DOC18/690434-02
SSD 8790

SSD 8790 – PARRAMATTA WEST PUBLIC SCHOOL REDEVELOPMENT – ENVIRONMENTAL IMPACT STATEMENT (EIS)

- ENVIRONMENT PROTECTION AUTHORITY COMMENTS – PARRAMATTA WEST PUBLIC SCHOOL REDEVELOPMENT

Title: SAMPLE LOCATION PLAN (DSI)	
Location: PARRAMATTA WEST PUBLIC SCHOOL, CRIMEA STREET, PARRAMATTA	
Report No: E31425KPrpt-RAP	Figure No: 2
ENVIRONMENTAL INVESTIGATION SERVICES

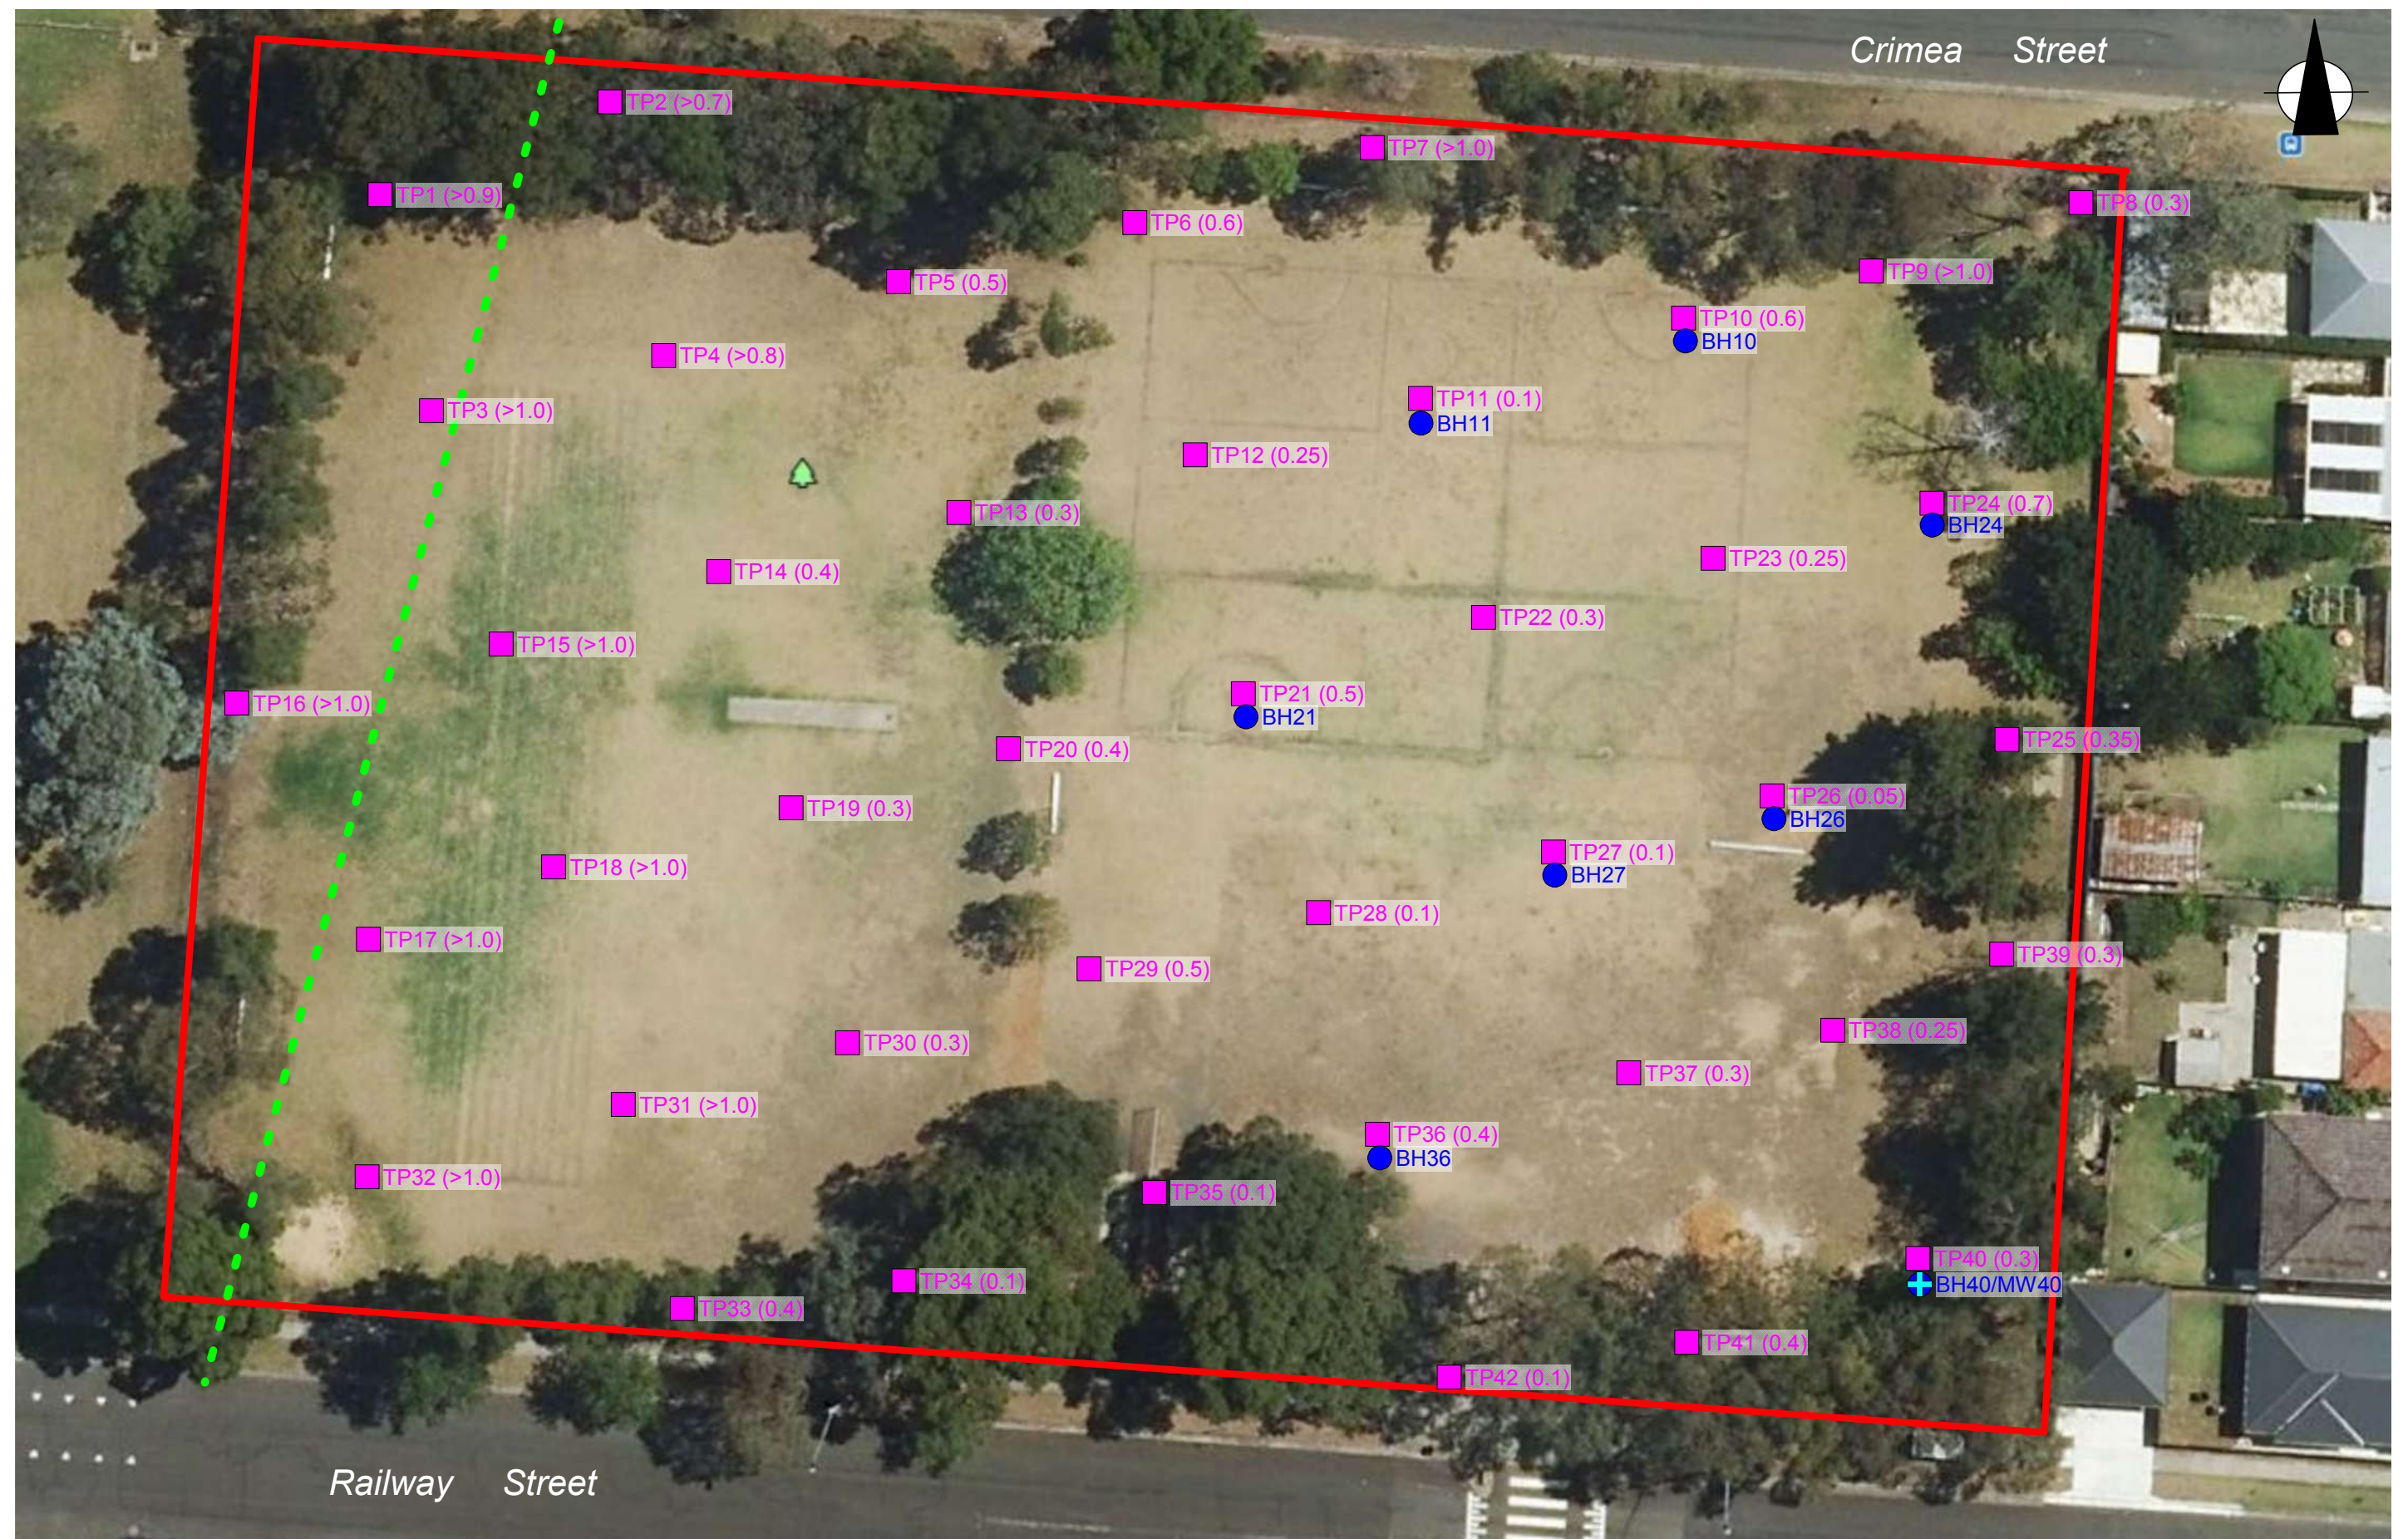
- (ii) confirm whether suspected asbestos containing material removed from the development site was disposed on at a landfill legally able to accept that waste,
- (iii) fully delineate the extent of some contaminants,
- (iv) include an adequate groundwater assessment,
- (v) clearly indicate where the asbestos samples were collected,
- (vi) clearly indicate if the soil contamination was vertically delineated, and
- (vii) indicate that a groundwater sampling well down hydraulic gradient of the 'the site' to determine whether suspected groundwater contamination was migrating off the site.

- TP15, asbestos in soil exceeding criteria at 0.1 to 1 m depth (no deeper samples tested). It is noted the Detailed site investigation indicated deepest fill (of >1.0 m, not defined how deep) was encountered on the western section of the investigation area; and
- TP30, total recoverable hydrocarbons in the >C16-C34 (F3) range exceeding criteria at 0.3 m depth (no deeper samples tested).

Title: REMEDIATION AREA PLAN	
Location: PARRAMATTA WEST PUBLIC SCHOOL, CRIMEA STREET, PARRAMATTA	
Report No: E31425KPrpt-RAP	Figure No: 4
ENVIRONMENTAL INVESTIGATION SERVICES

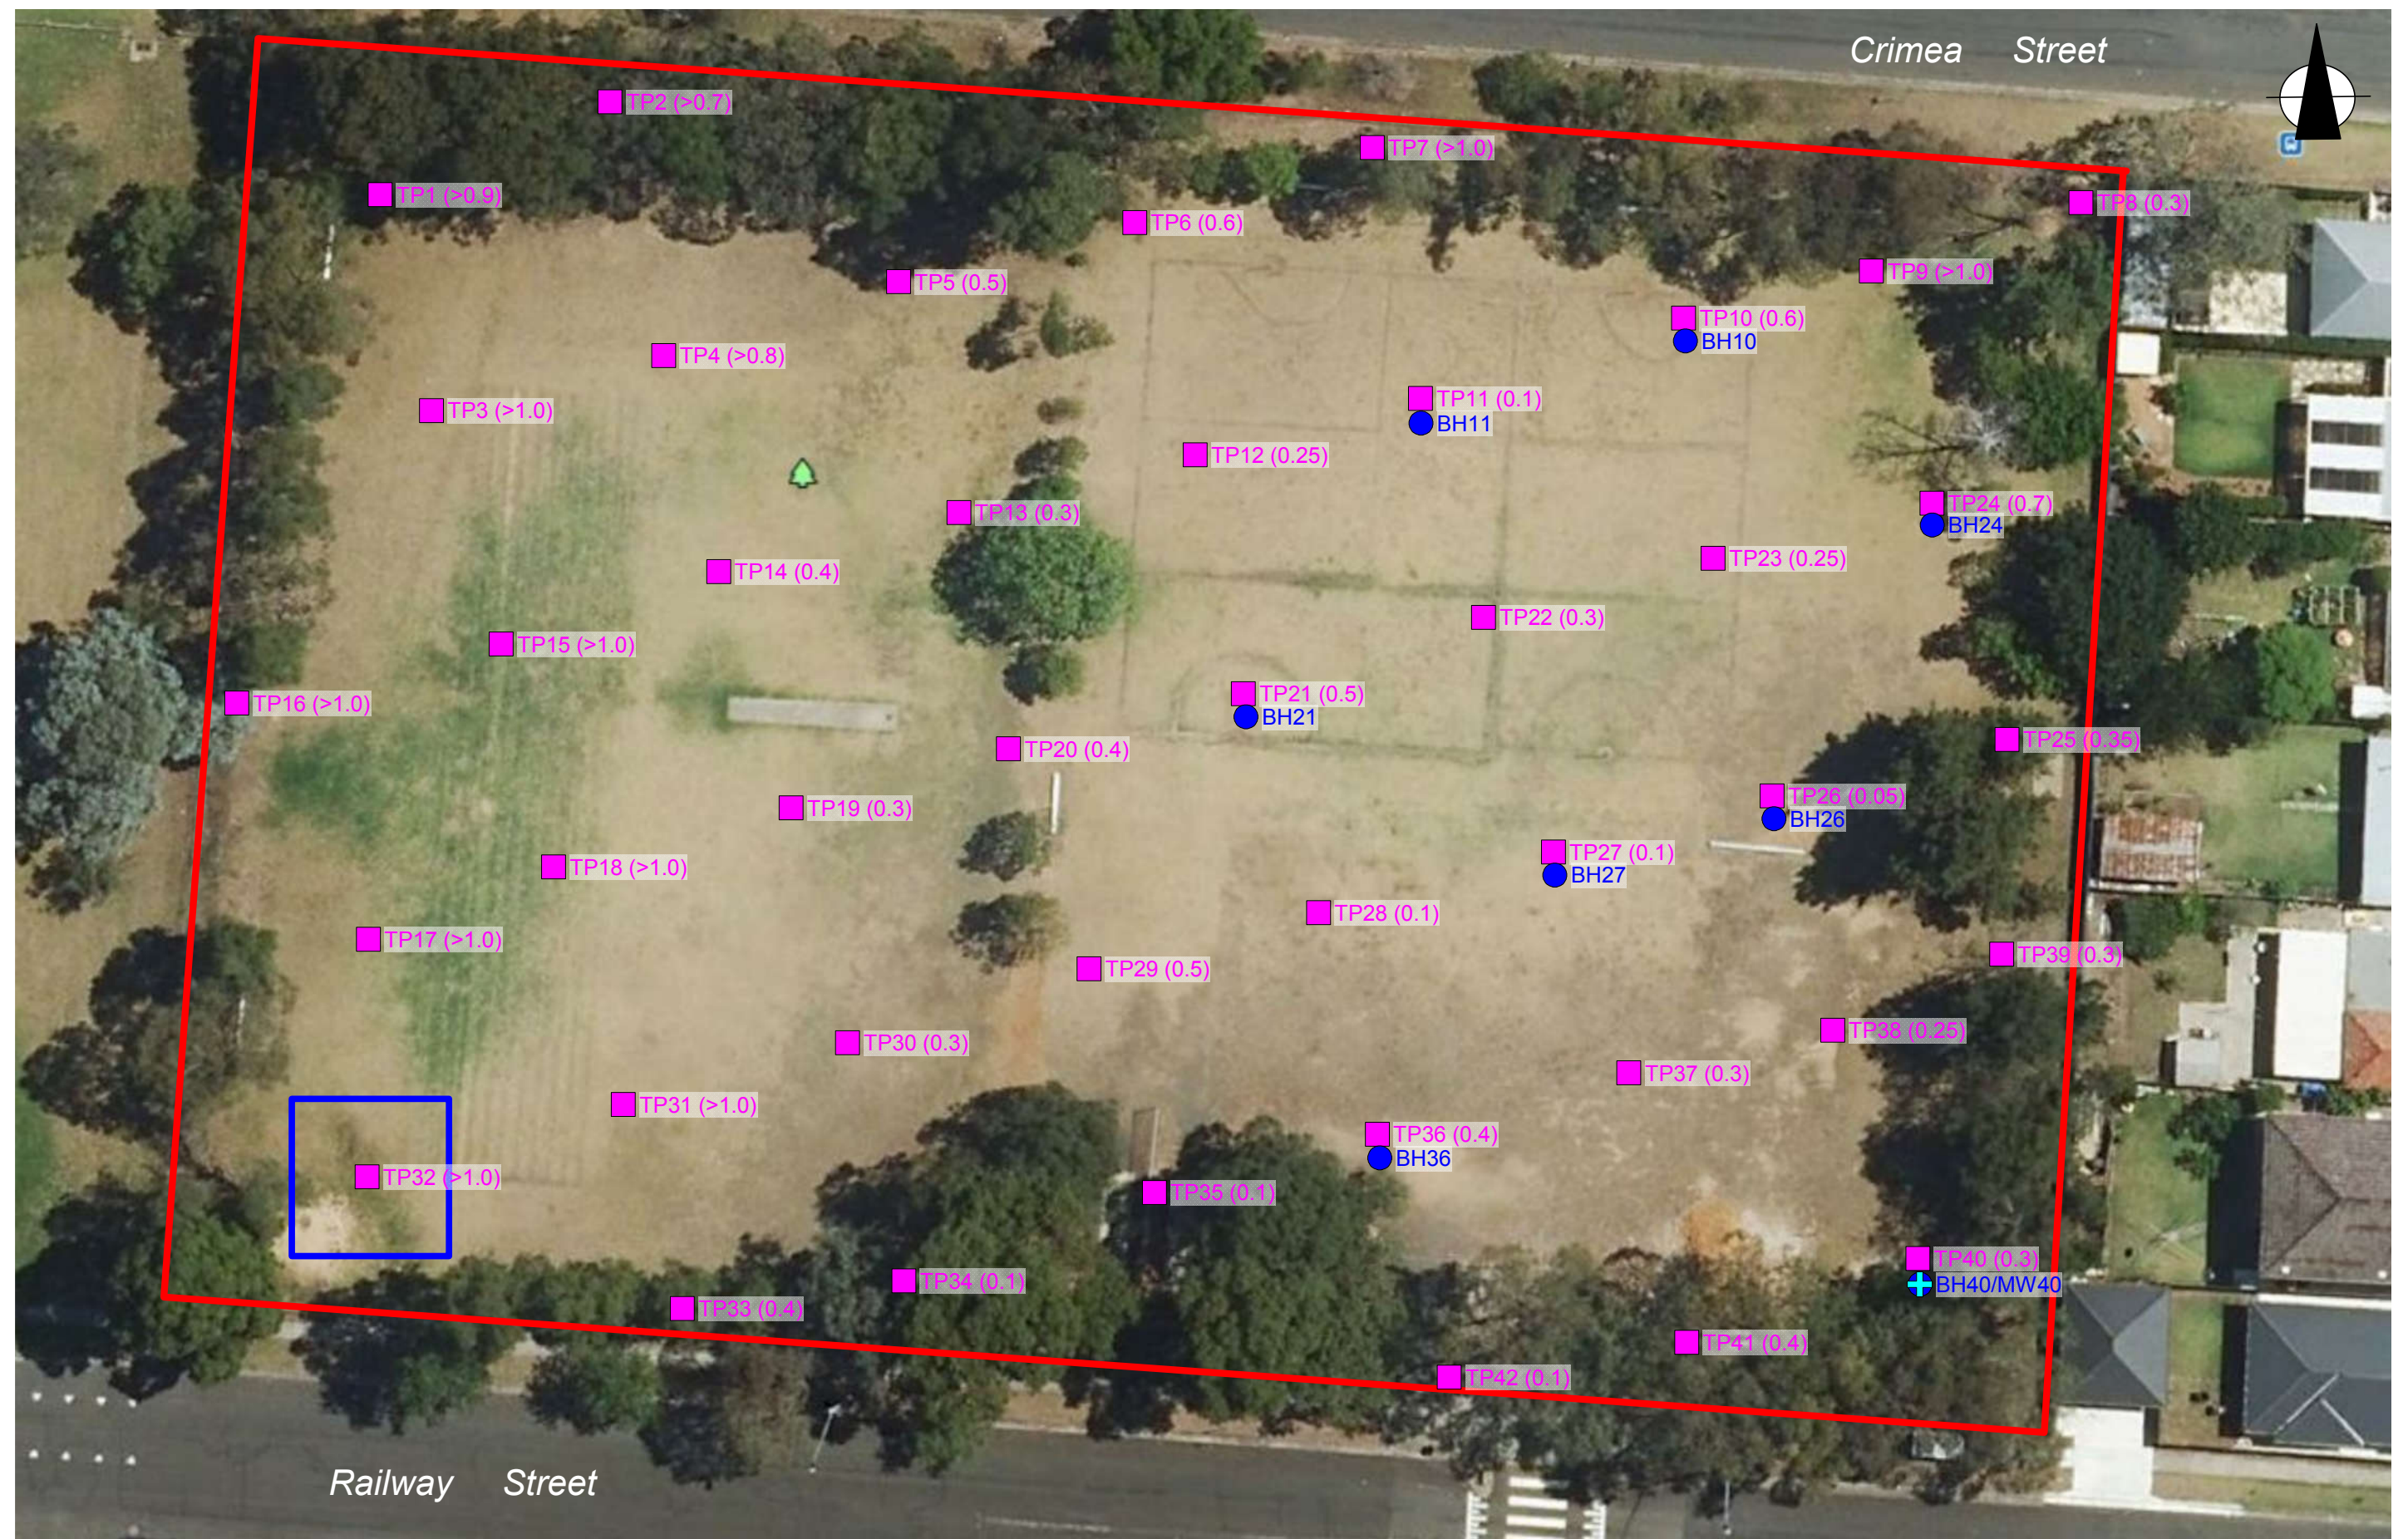
EIS Appendix CC '*Remediation Action Plan*' proposes capping and containment of asbestos contaminated soils with a 300 millimetres cap of clean fill over the marker layer. However, the Western Australian DoH '*Guidelines for the Assessment, Remediation and Management of Asbestos-Contaminated Sites in Western Australia – May 2009*' recommends the depth of the clean fill should be at least 1 m for public open spaces and at least 0.5 m for all other uses, such as residential or commercial activities.

Accordingly, the EPA considers the emplacement of only 300 millimetres of clean material over the marker layer and no cap under hardstand areas poses a potential risk to future users.

EIS Appendix CC proposes the excavation and removal of PAH contaminated soil but omits any remediation of other hotspots of contamination (e.g. Pb and TRH).
